#### Detention Pond D2 (Full Spectrum Design, Ultimate Conditions)

Project: **Lorson East MDDP (100.013)**

Basin ID: **Pond C5 (only used for WQCV and EURV) Do not use for 2-100-yr Storm Event!!!!!!**

LORSON RANCH EAST FILING NO. 1
FULL SPECTRUM POND C5
OUTLET STRUCTURE

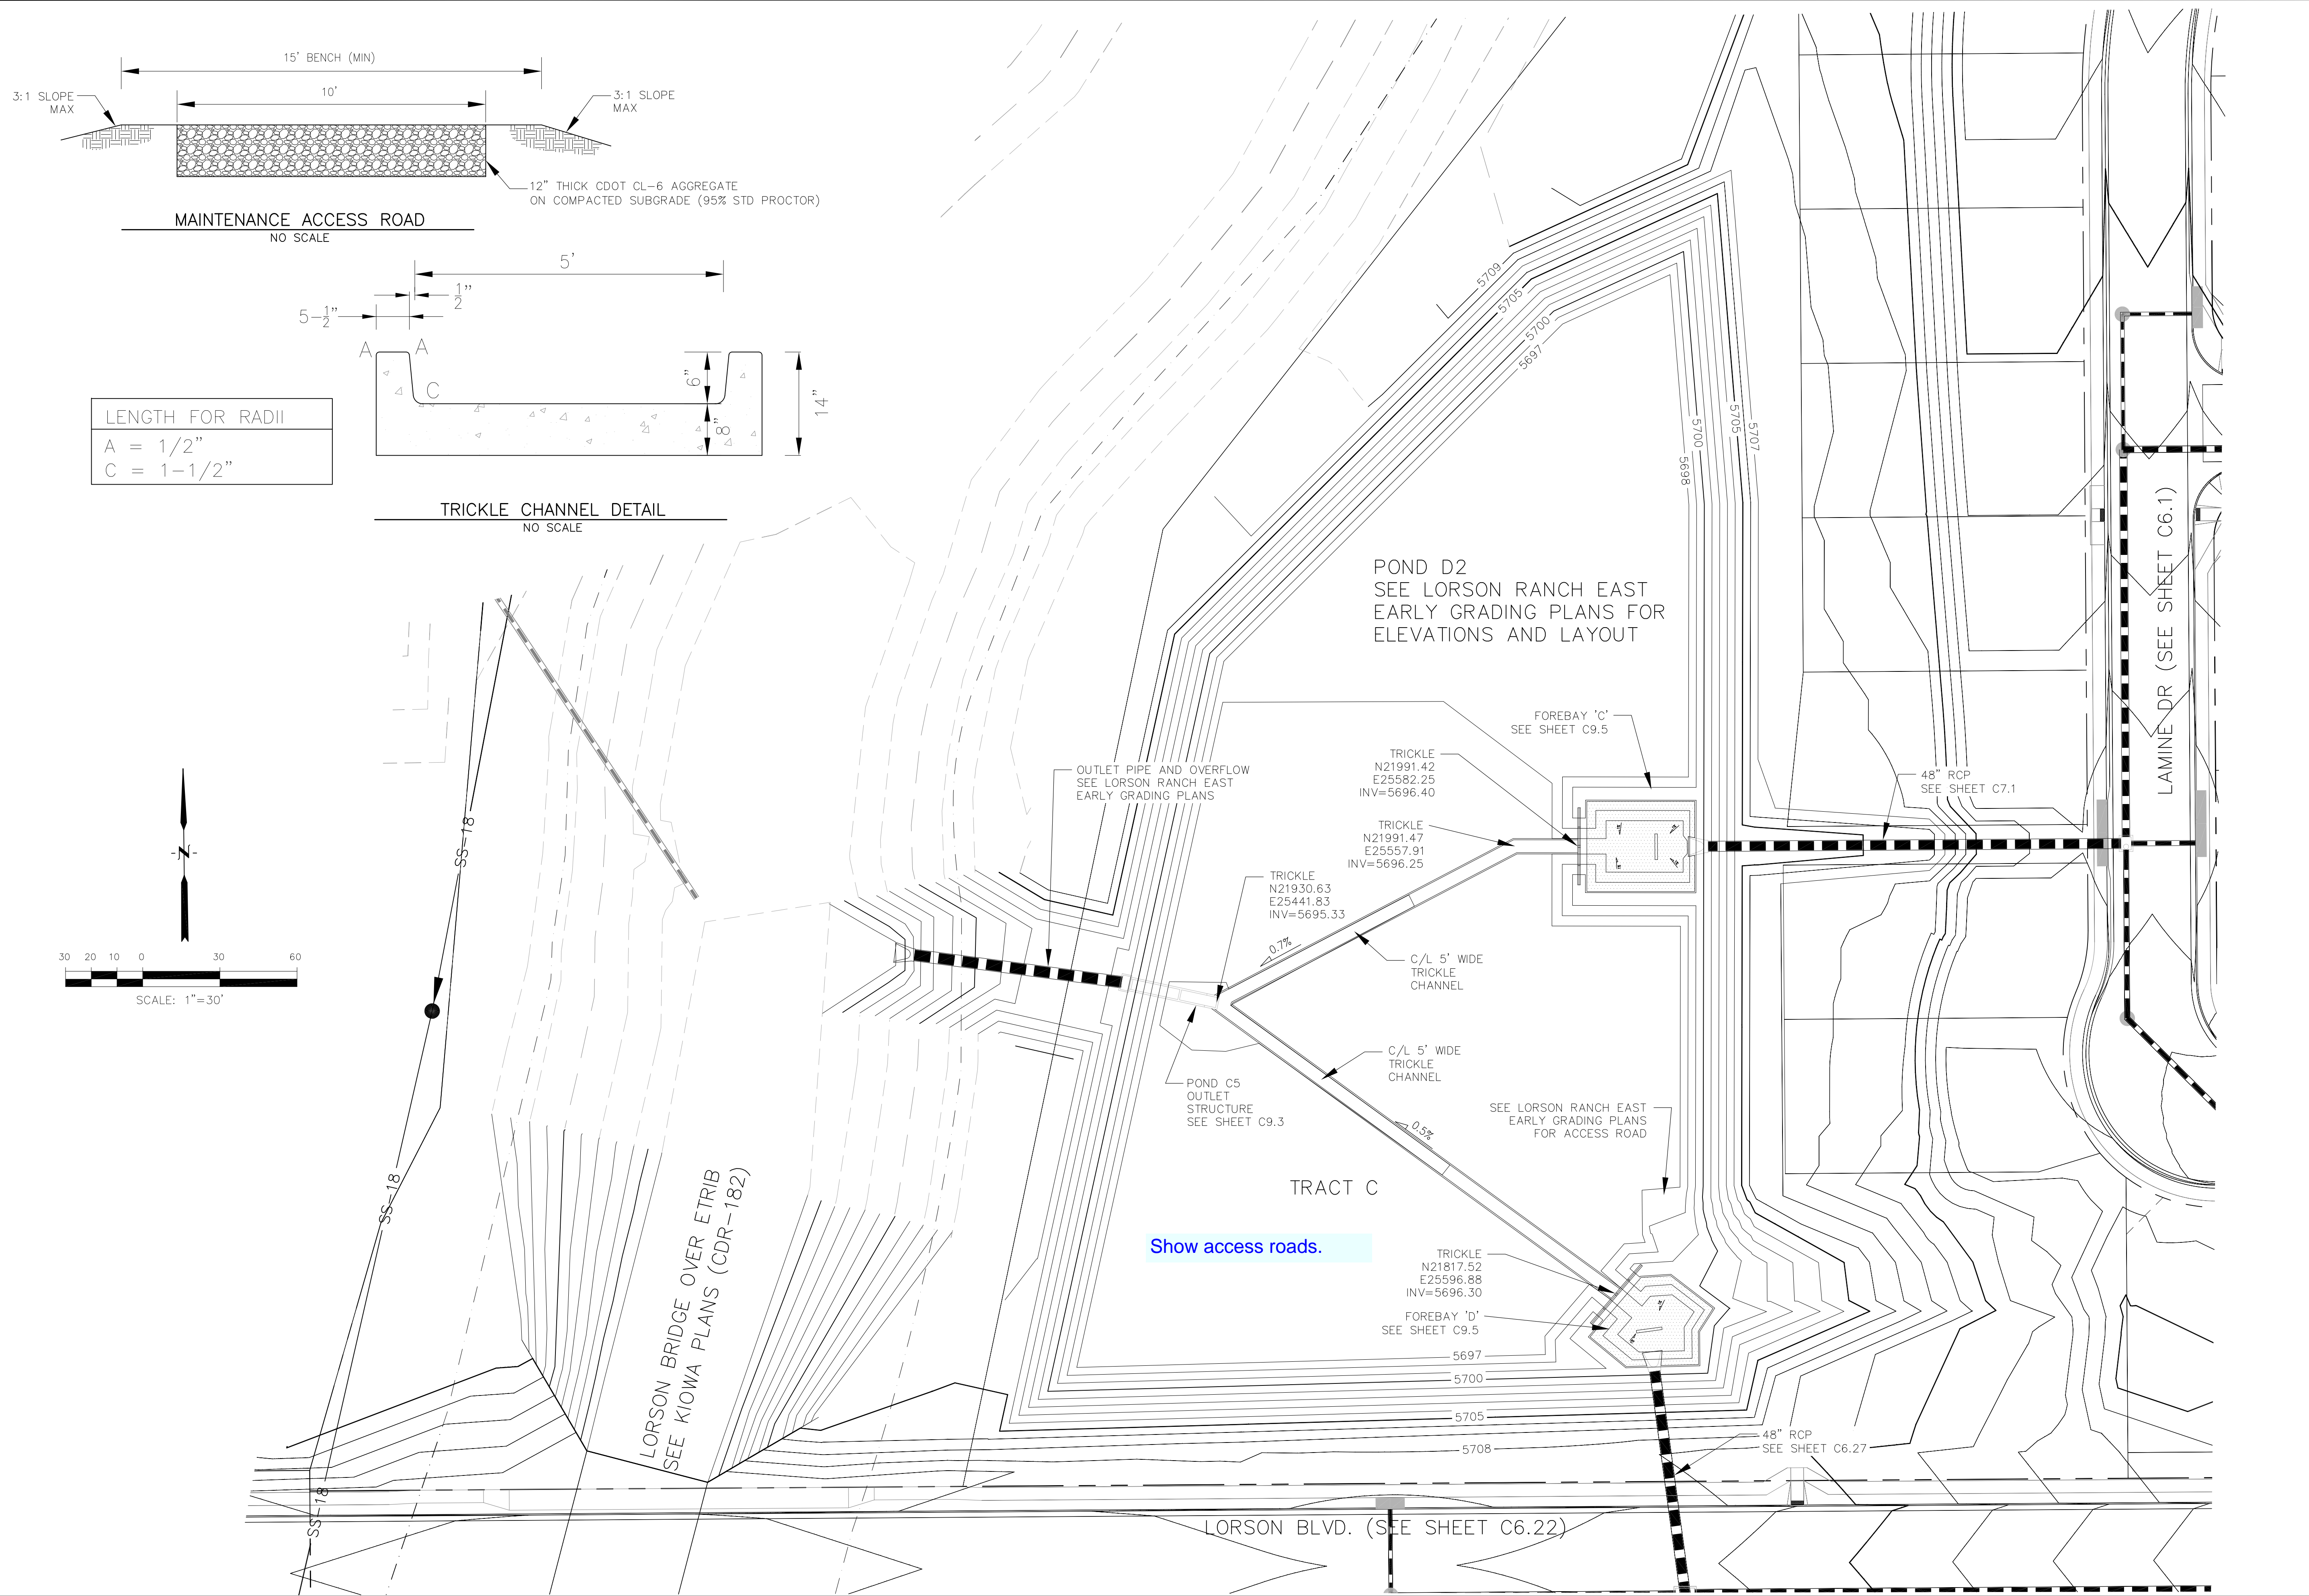
Adjust to be  
1 or less

Replace the SSD sheet.
